June 28, 2016

Re: Dunkin donuts Renovation
5502 4th St., NW
Traffic Circulation Layout
Engineer's/Architect's Stamp **3-15-16** (F14-D013)

Based upon the information provided in your submittal received 6-27-16, the above referenced plan cannot be approved for Building Permit until the following comments are addressed:

DD FRESH BREW / BR FLAVORS 1.0 COMBO DESIGN GUIDELINES
SCHEMATIC SITE PLANS AND TRAFFIC CIRCULATION LAYOUT
PC NUMBER

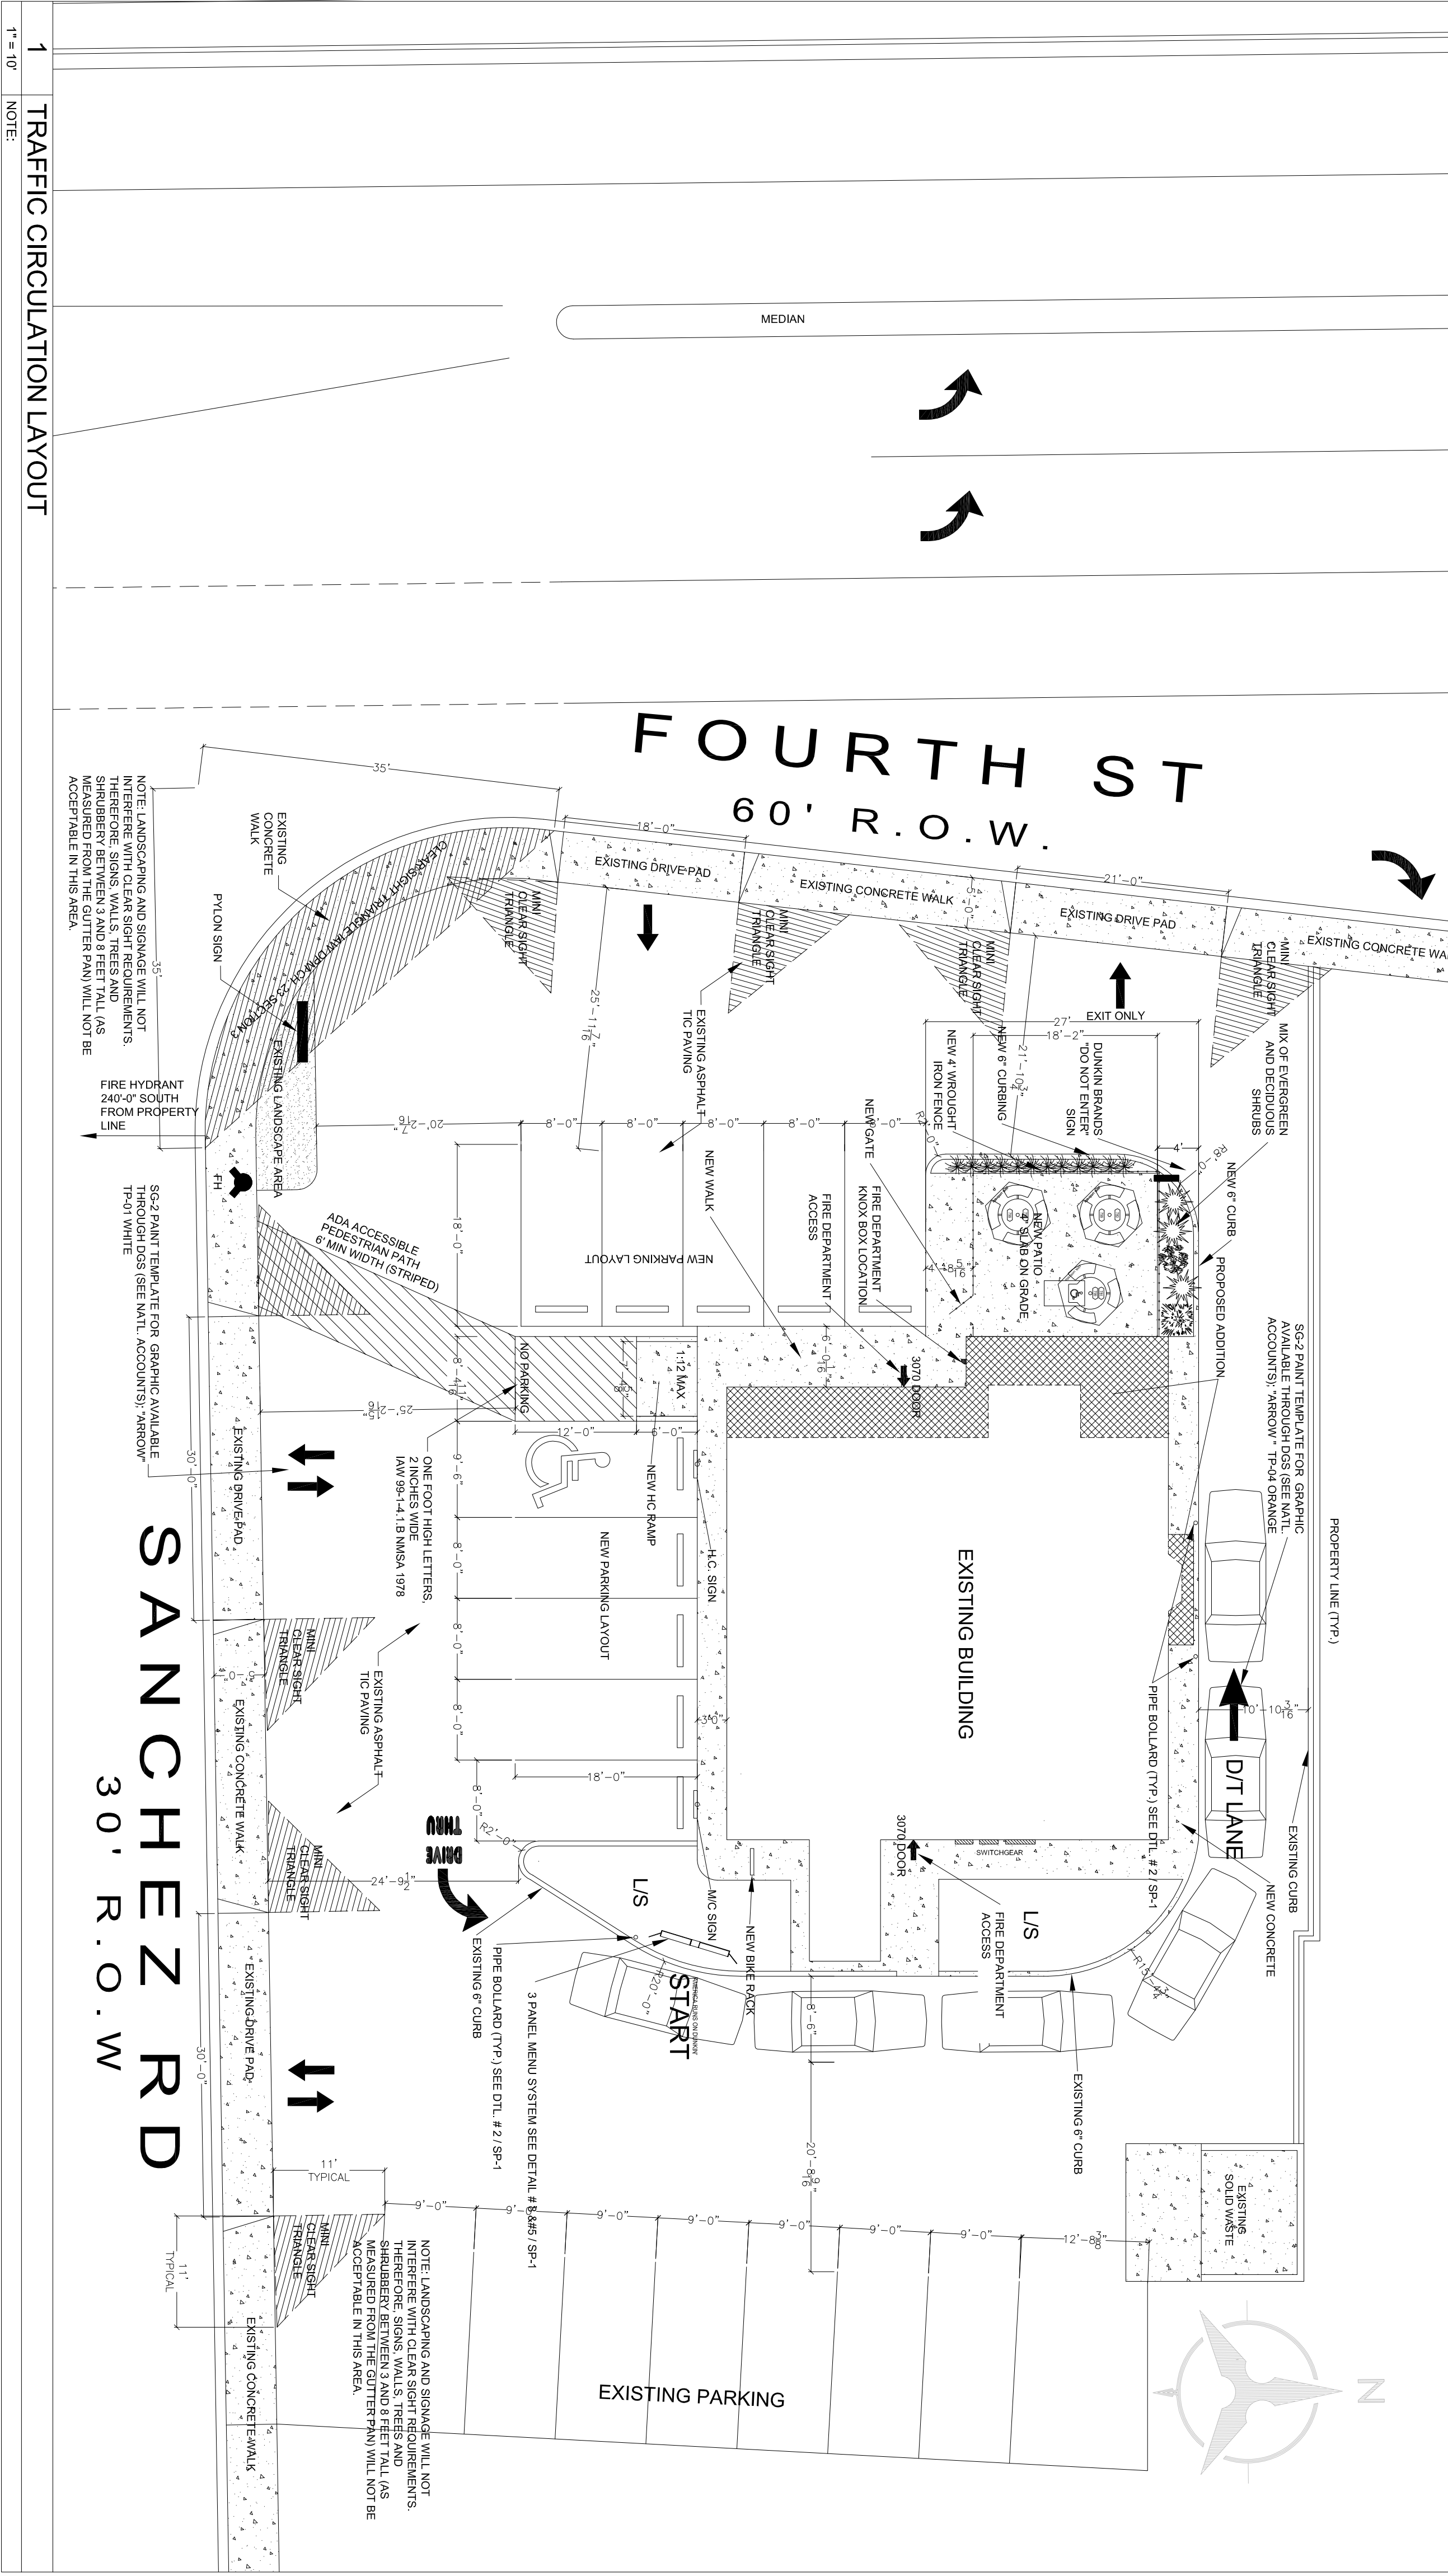
1. List the number of parking spaces required by the zoning code as well as the proposed number of parking spaces.
2. Clarify the extents of the current phase.

3. Please identify and dimension all existing doors, sidewalks, curbs, ADA ramps, drive pads, wall and anything that influences the parking and circulation on the site.

4. Identify the right of way width, medians, curb cuts, and street widths on 4th St. and Sanchez Rd.
5. Please list the width and length for all existing and proposed parking spaces.

6. The ADA accessible parking sign must have the required language per 66-7-352.4C NMSA 1978 **"Violators Are Subject to a Fine and/or Towing."** Please call out detail and location of HC signs. Please show a detail or call out this language.

7. The ADA access aisles shall have the words **"NO PARKING"** in capital letters, each of which shall be at least one foot high and at least two inches wide, placed at the rear of the parking space so as to be close to where an adjacent vehicle's rear tire would be placed. (66-1-4.1.B NMSA 1978)

8. Per DPM, a 6 ft. wide ADA accessible pedestrian pathway is required from the public sidewalk to the building entrances. Please clearly show this pathway and provide details.

9. Per DPM, a 6 ft. wide ADA accessible pedestrian pathway is required from the HC parking stall access aisles to the building entrances. Please clearly show this pathway and provide dimensions.

10. Provide a min 6" or max 8" high concrete barrier curb or other acceptable barrier between landscaping and parking areas and/or drive aisles. Please call out detail and location of barrier curb.
11. Service vehicle and/or refuse vehicle maneuvering must be contained on-site; provide a copy of refuse approval.
12. One-way vehicular paths require pavement directional signage and a posted "Do Not Enter" sign at the point of egress. Please show detail and location of posted signs.
13. Please provide a sight distance exhibit (see the *Development Process Manual, Chapter 23, Section 3*). Please show this detail for the intersection of 4th St. and Sanchez Rd. Please show the Mini Clear Sight Triangle detail for the other entrances off of 4th St. and Sanchez Rd.

14. Please add the following note to the clear sight triangle: "Landscaping and signage will not interfere with clear sight requirements. Therefore, signs, walls, trees, and shrubbery between 3 and 8 feet tall (as measured from the gutter pan) will not be acceptable in this area."
15. Unused curb cuts must be replaced with sidewalk and curb & gutter. A build note must be provided referring to the appropriate City Standard drawing.

16. All broken or cracked sidewalk must be replaced with sidewalk and curb & gutter. A build note must be provided referring to the appropriate City Standard drawing.
17. Please include two copies of the traffic circulation layout at the next submittal.
